October 25, 2022

Re: Curia Building Addition
4401 Alexander Blvd NE Albuquerque, NM 87107
Grading and Drainage Plan (F16D003B1)
Letter of Response

On behalf of Curia New Mexico LLC (f/k/a Oso Biopharmaceuticals, LLC), Burns & McDonnell is pleased to submit this Letter of Response to the Grading and Drainage Plan (F16D003B1) comments received September 20, 2022. Response to comments are located below in italics and on enclosed drawings.

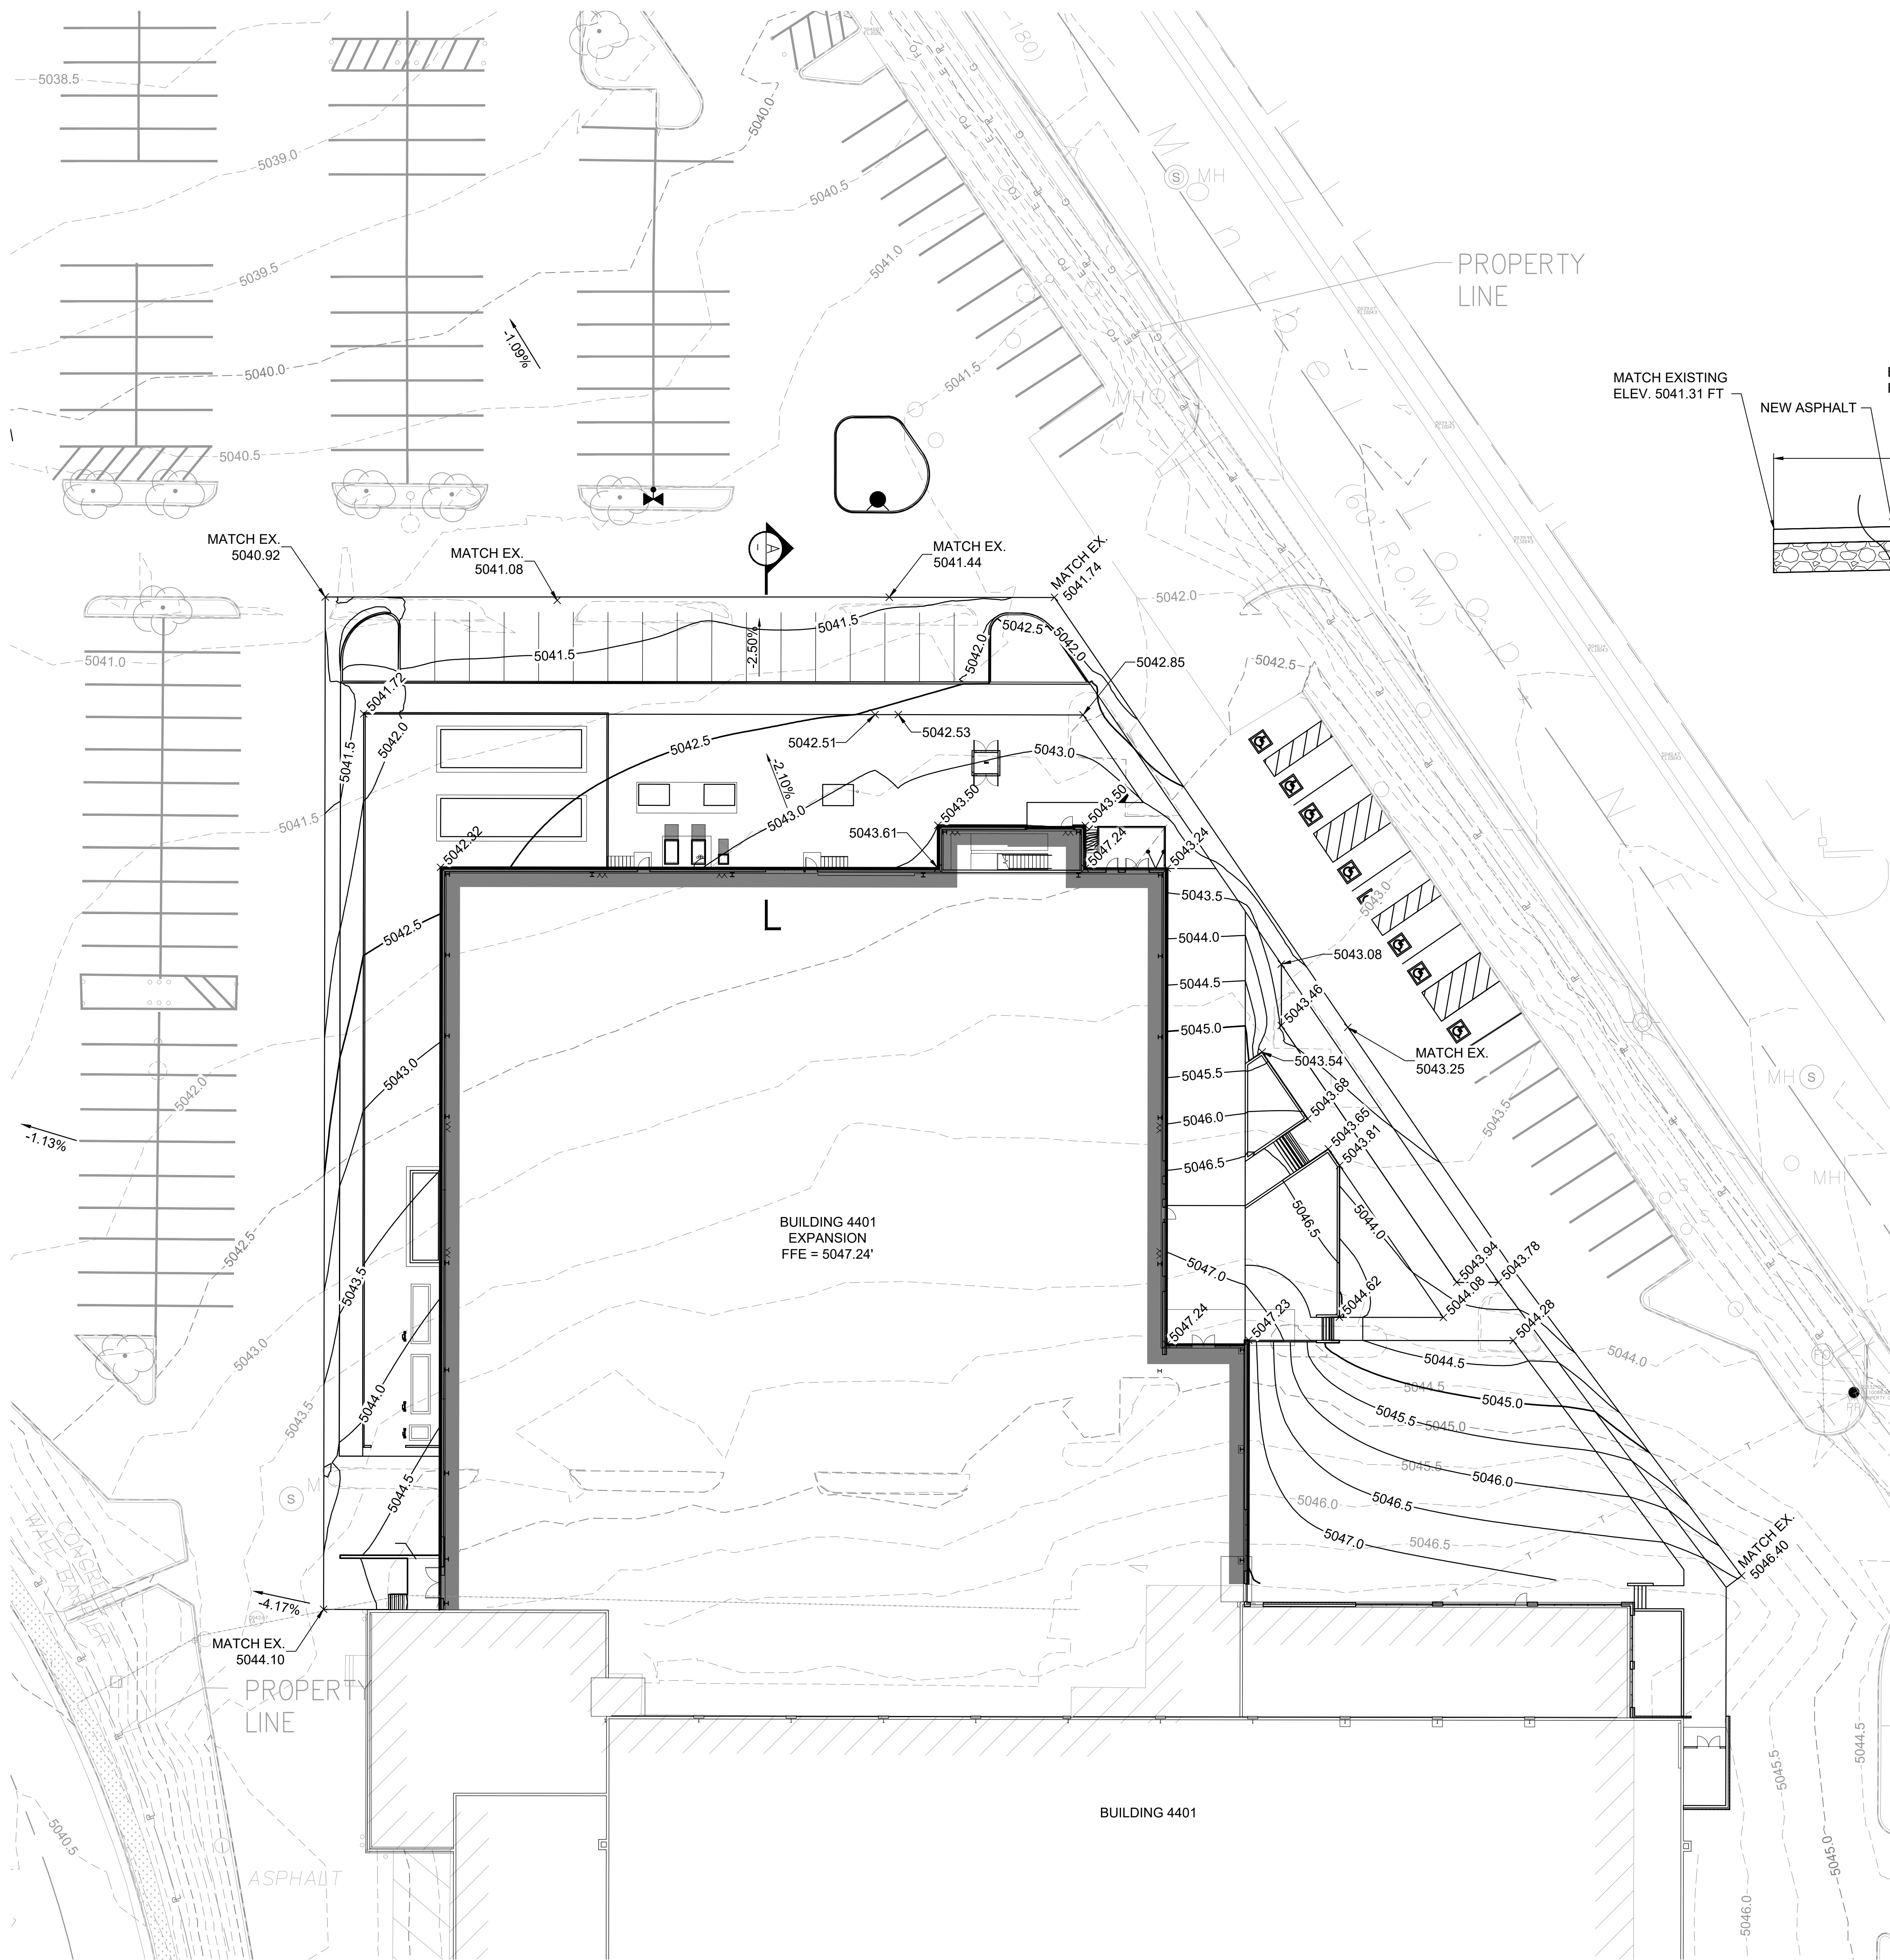
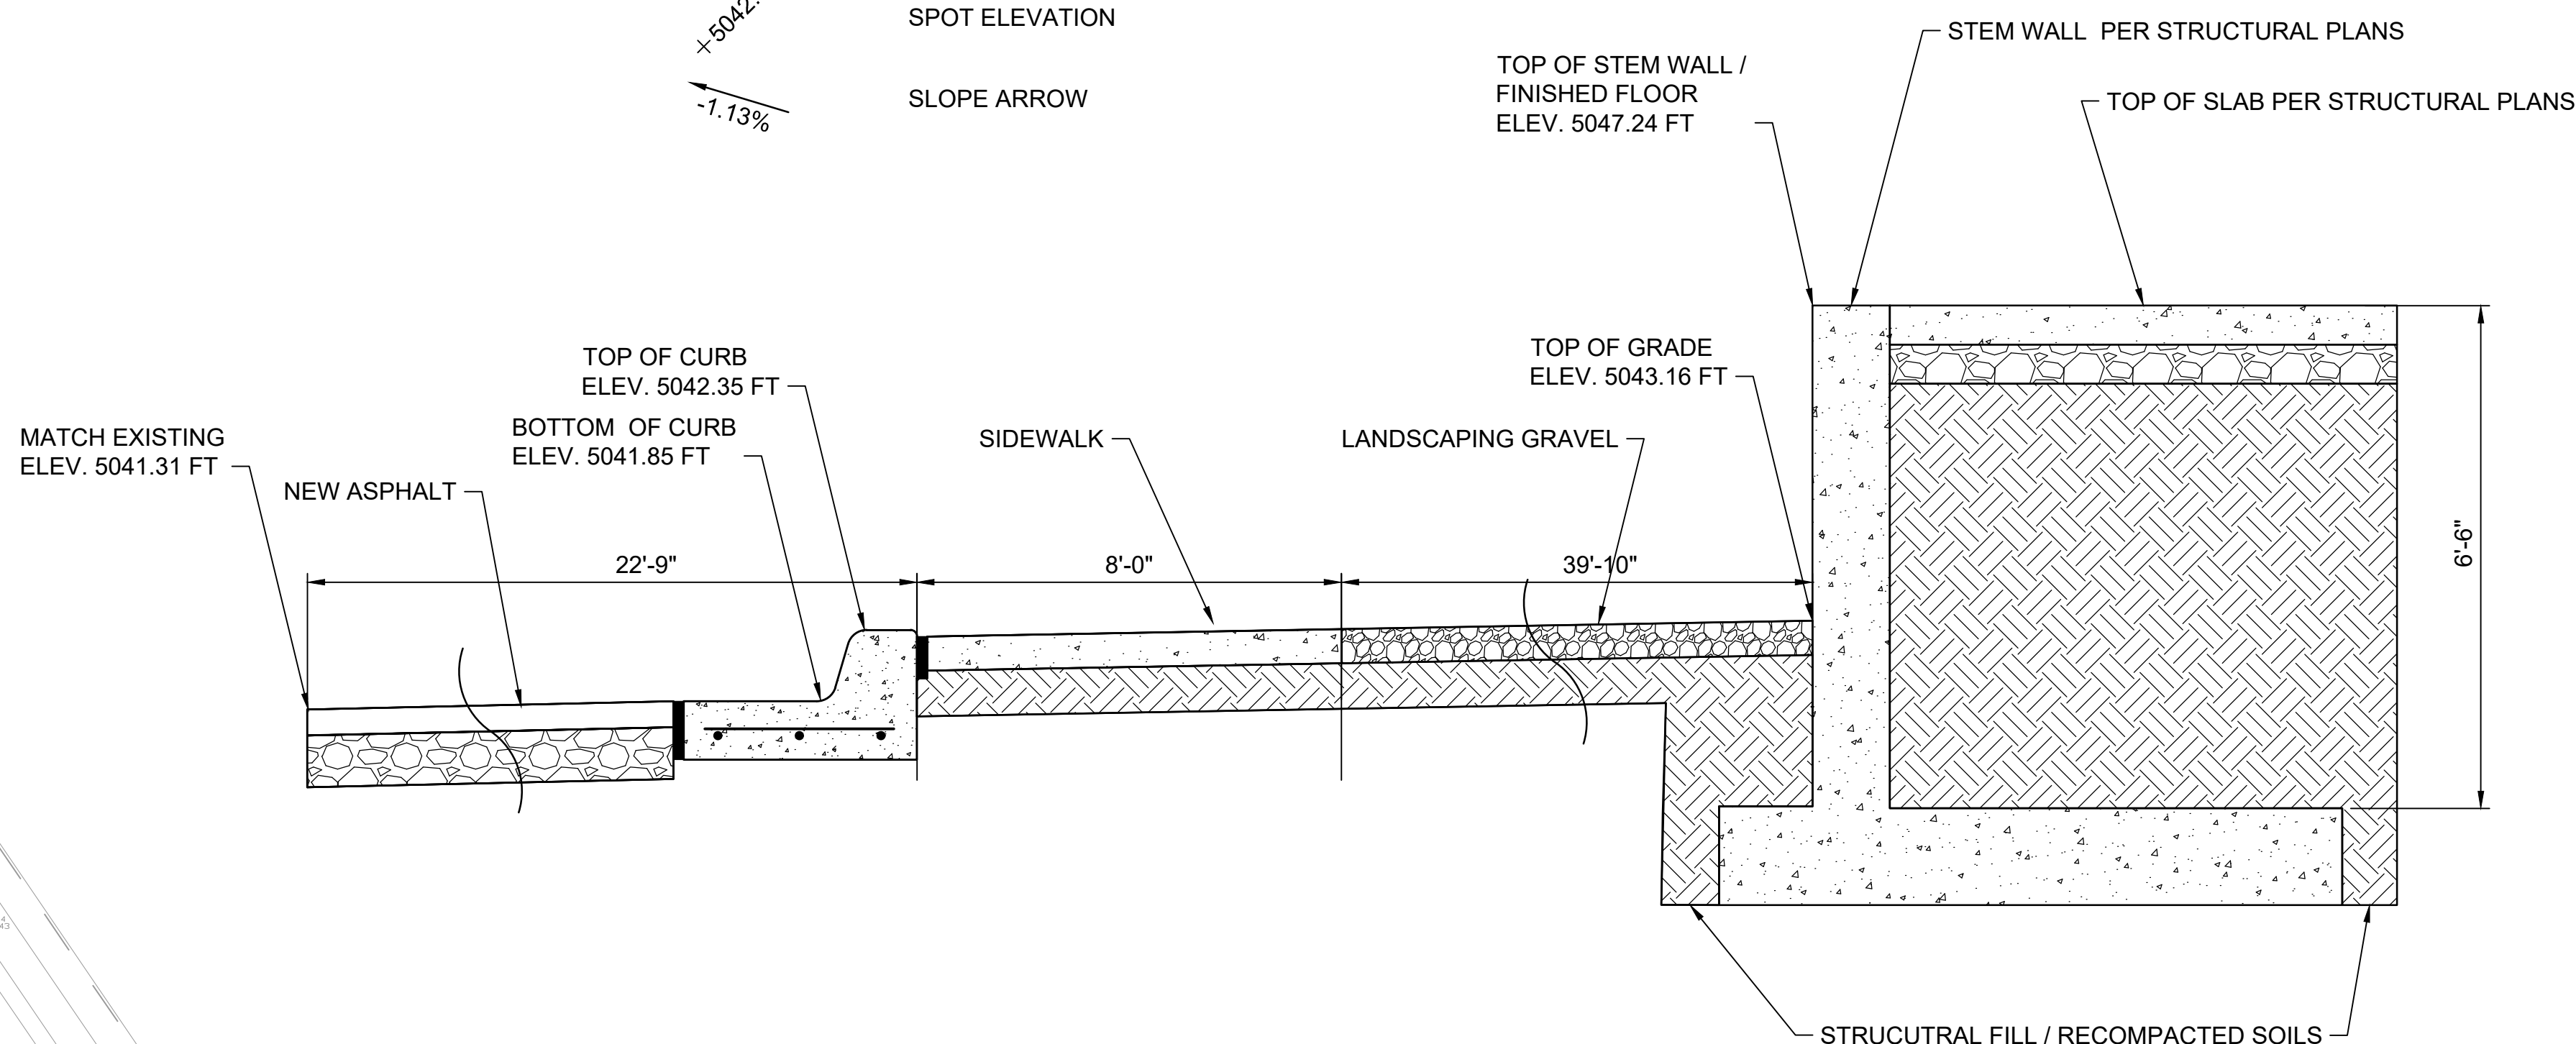
- 4) Provide detail elevation and finished contours around the building and beyond to show how it will tie to the existing grades. To the north the Finished Floor elevation is nearly 6' about the exiting grade. Are there going to be stem walls. Provide cross-sections.
Finish grade and cross section are included on drawing CG102 Enlarged Grading & Drainage Plan.
